Subject: RE: Planning Re-Consultation on: AL/59/21/DOC

Thank you for reconsulting us on this application. The revised design is an improvement over the previous scheme as a gravity system is now proposed. However, we still have a significant number of comments.

Application No: AL/59/21/DOC
Registered: 25th May 2021
Site Address: Springfield Hook Lane Aldingbourne PO20 3TE
Grid Reference: 493480 104546
Category: Discharge of Condi
Description of Works: Approval of details reserved by condition imposed under AL/64/20/PL relating to conditions 9-foul drainage, 10-surface water drainage, 11-flows discharge & 12-maintenance & management of surface water drainage.

STORM DRAINAGE LAYOUT
1:100

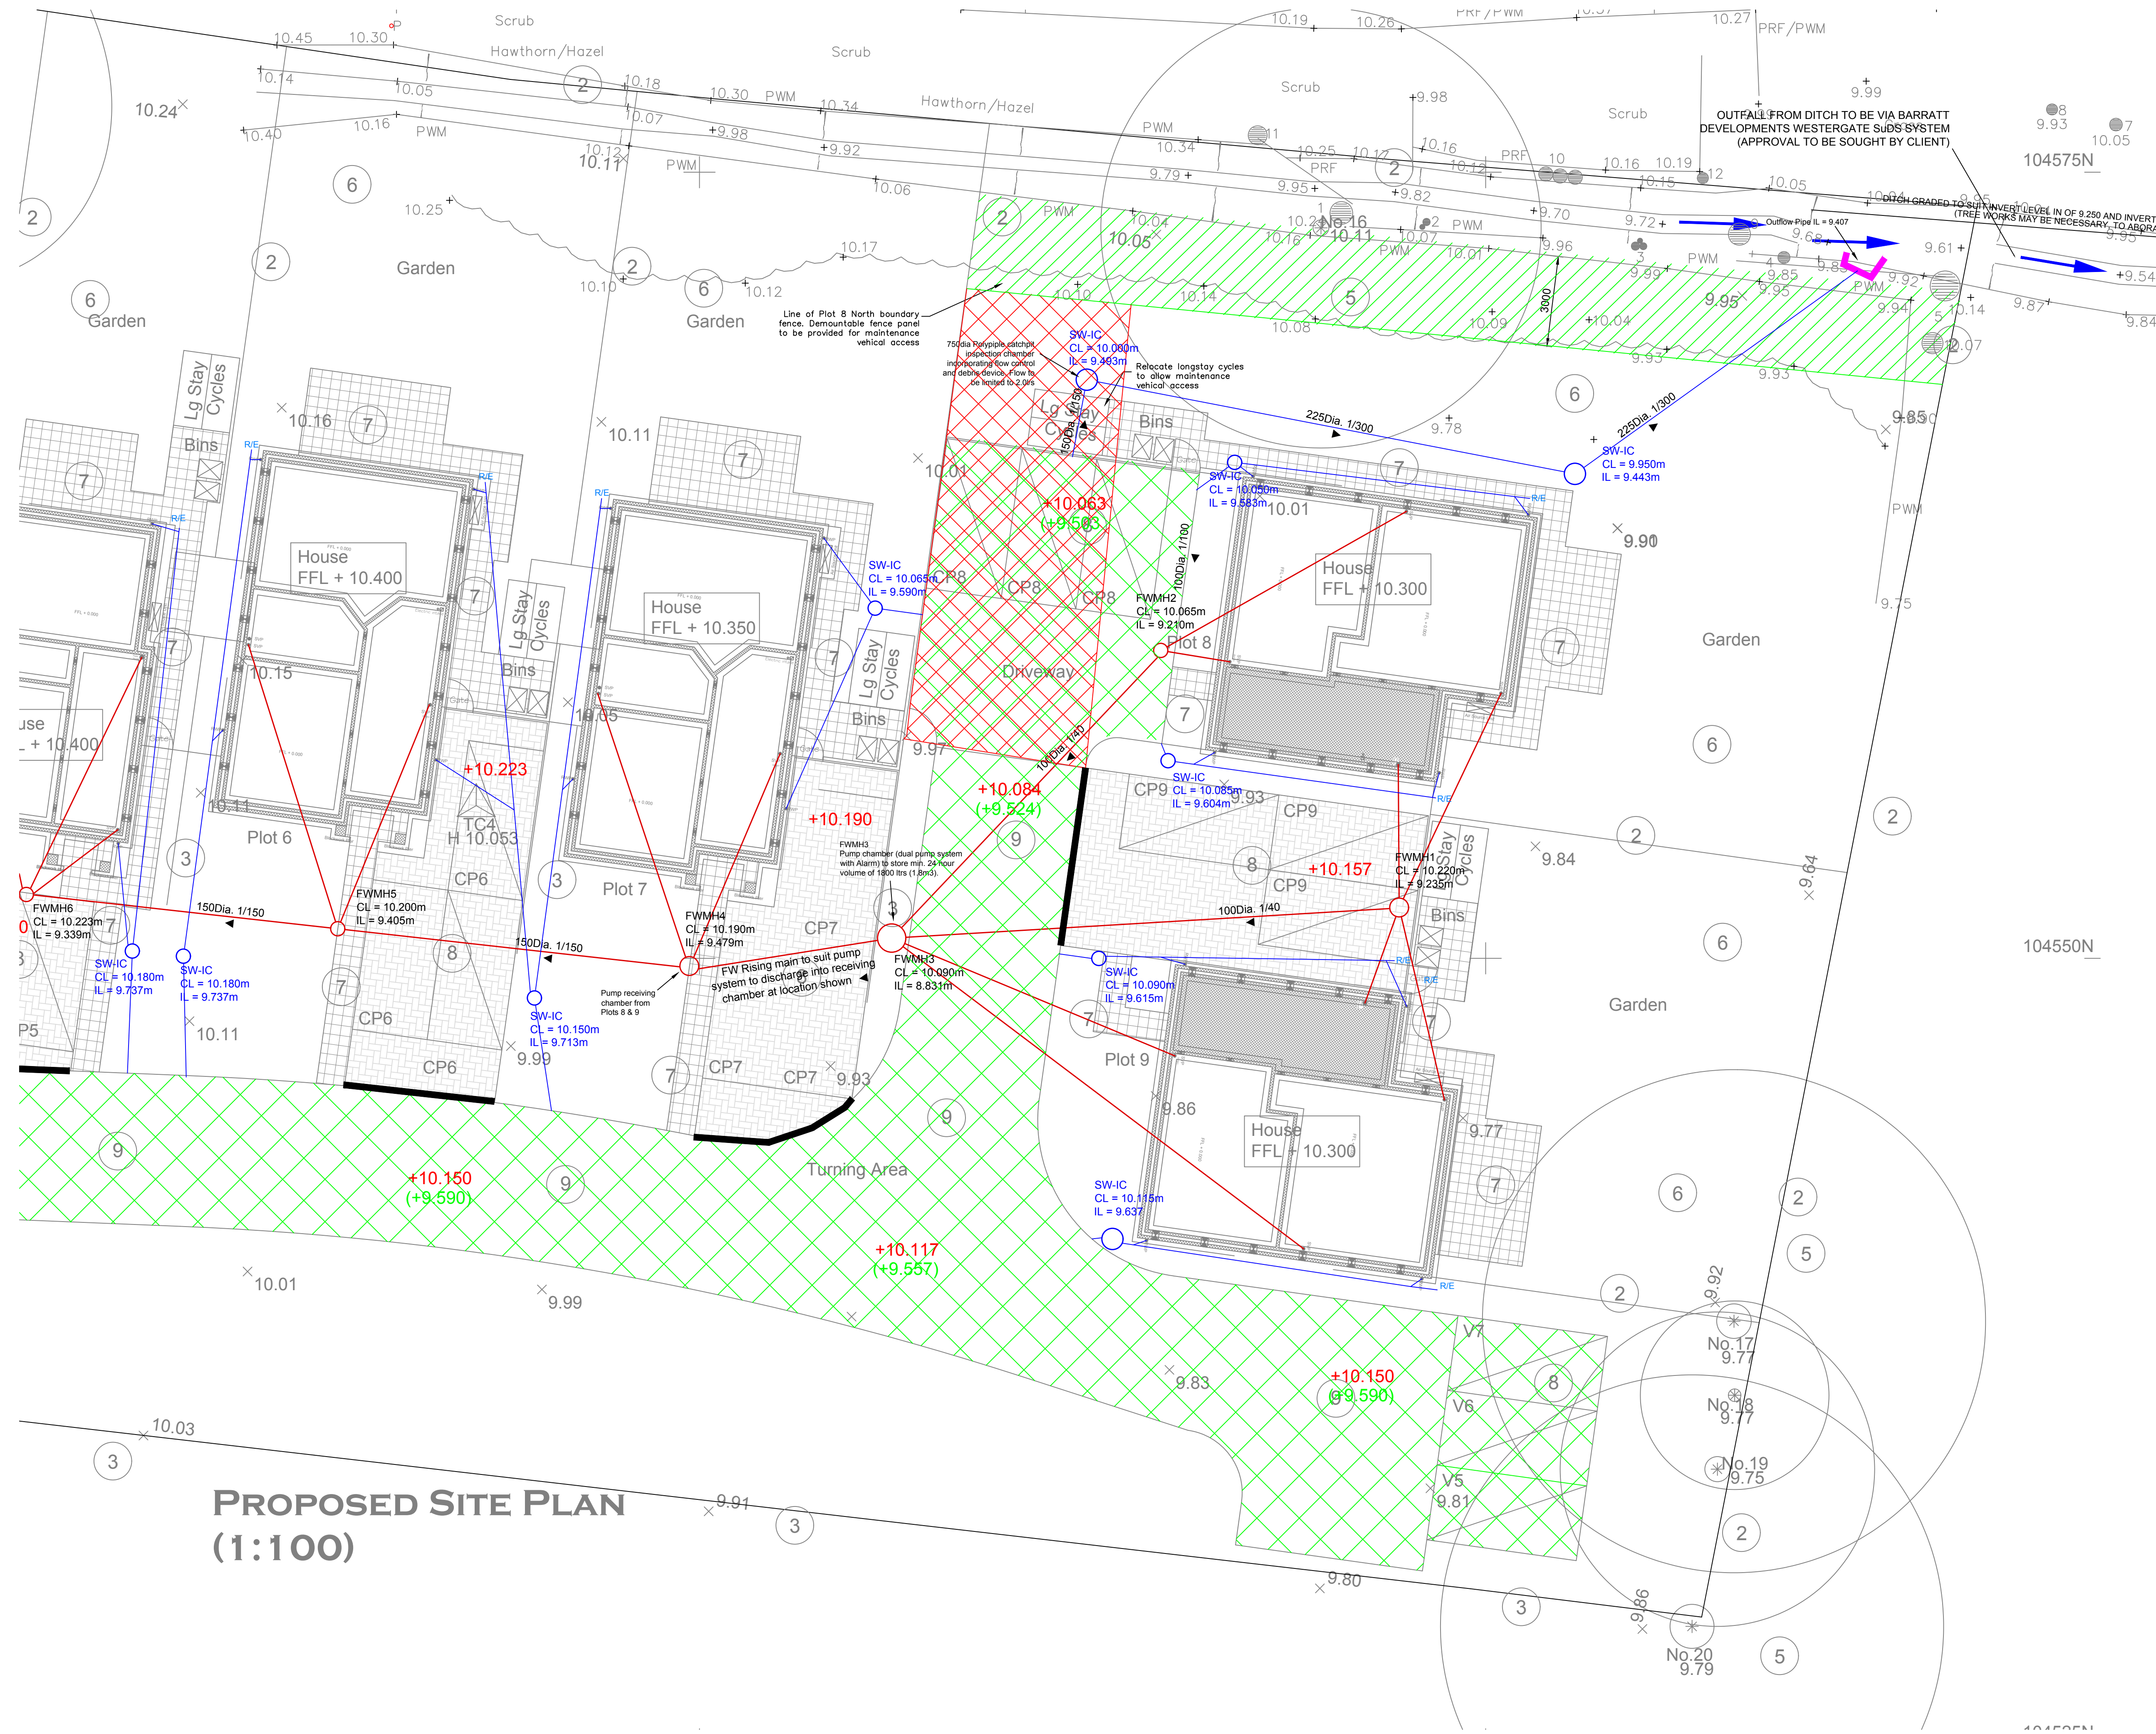
4. Invert levels of all pipes connecting into the permavoid need to be detailed on plan. As well as the outlet level.

5. Catchpits are required upstream of all connections into the permavoid/ sub-base, this requirement should be clearly shown on plan.
6. The proposed road make up is very confusing- permeable asphalt is proposed over type 1 (not permeable) which receives water from permachannels. The type 1 then overlies the permavoid tanks which are detailed to be fully encapsulated in an impermeable liner. This simply does not work, provide a permeable link between the road surface and permavoids must be provided. Please provide a permeable sub-base material, e.g. type 3, and a permeable geotextile fully wrapping around the crates. If an impermeable liner is required this should be around the base of the tanks and then up the sides of the tank and sub-base.

9. A site specific construction detail drawing of the hydrobrake chamber is required.
10. The fall of the pipe from the permavoid to the ditch is insufficient. All pipes must achieve 1m/s self cleansing velocity. I haven't been able to scale off your plan (as I do not have access to a plotter today) to examine the slope of the permavoids/sub-base, but is there potential to slacken this at all?

11. Please label all pipes with diameter and fall.
12. I note that the invert level of the ditch outlet has now been established. As detailed by Paul previously "*The existing ditch re-grading is noted, however, your topo survey needs to extend all the way to where the ditch outfalls into Barratts suds system via an existing 300mm pipe. Information should include the invert level of their pipe and any existing trees on route that may interfere with regrading this ditch to the desired levels. We can then have a further discussion in terms of what can be achieved. Existing trees are known to be growing in the ditch bed and will no doubt require discussions with an arboriculturist and possibly our tree officer.*" We need to have this information and complete these further discussions to establish for certain what outlet level is acceptable from your site.

DETAIL A - SECTION THROUGH PERMEABLE ACCESS ROAD INCORPORATING POLYPIPE PERMAVOID SUB-BASE REPLACEMENT ATTENUATION SYSTEM
SCALE 1:15

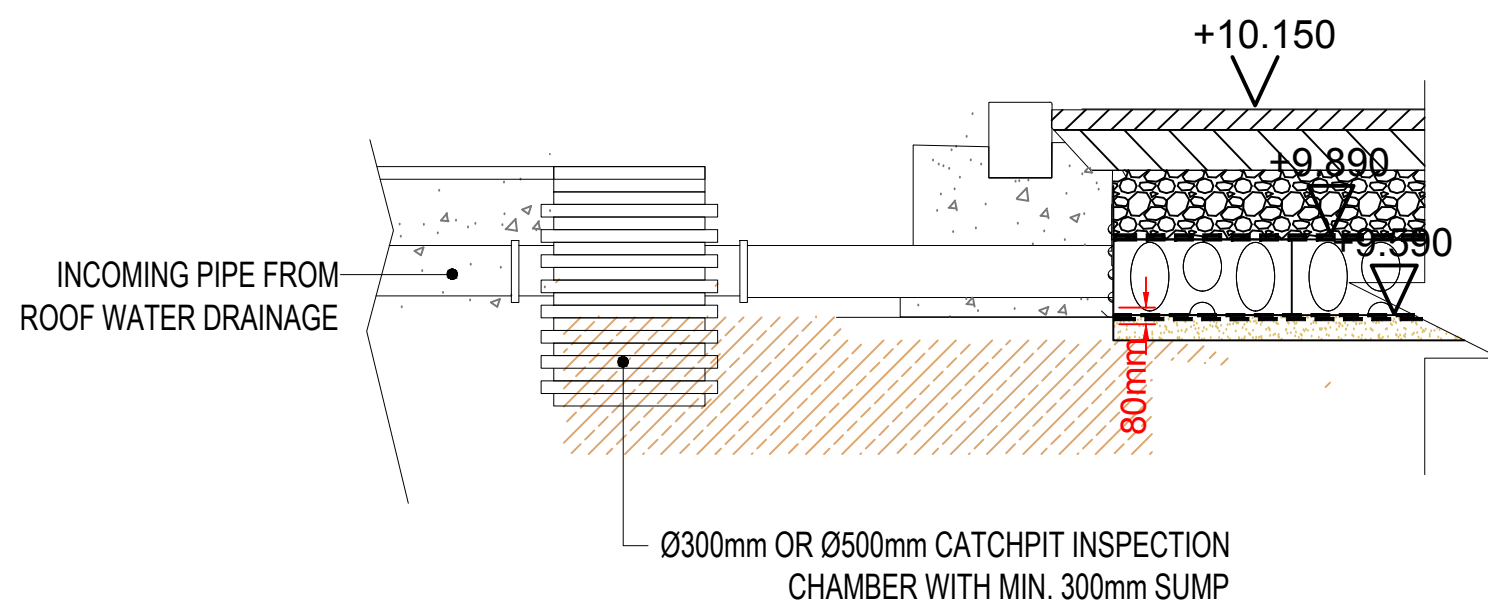
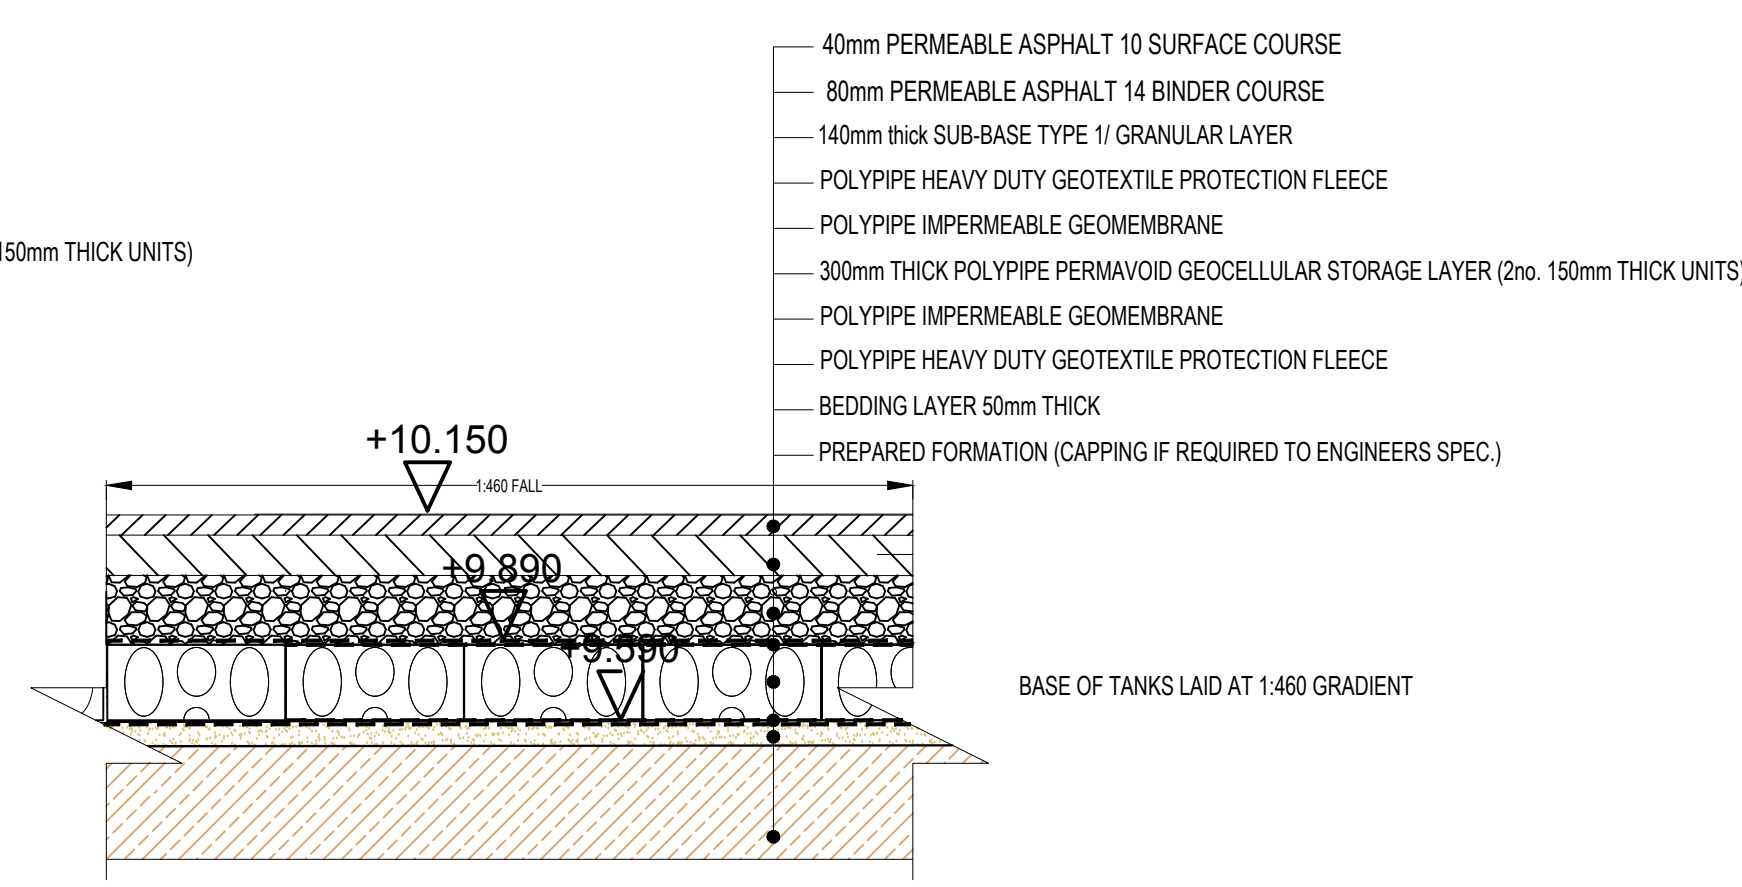
7. It needs to be indicated on plan where the section drawing relates to as road levels vary throughout the site.
8. Can driveways be redesigned to have a fully permeable make up linking to the sub-base of the road to provide greater storage and treatment at source? Rather than having to rely upon proprietary treatment devices.
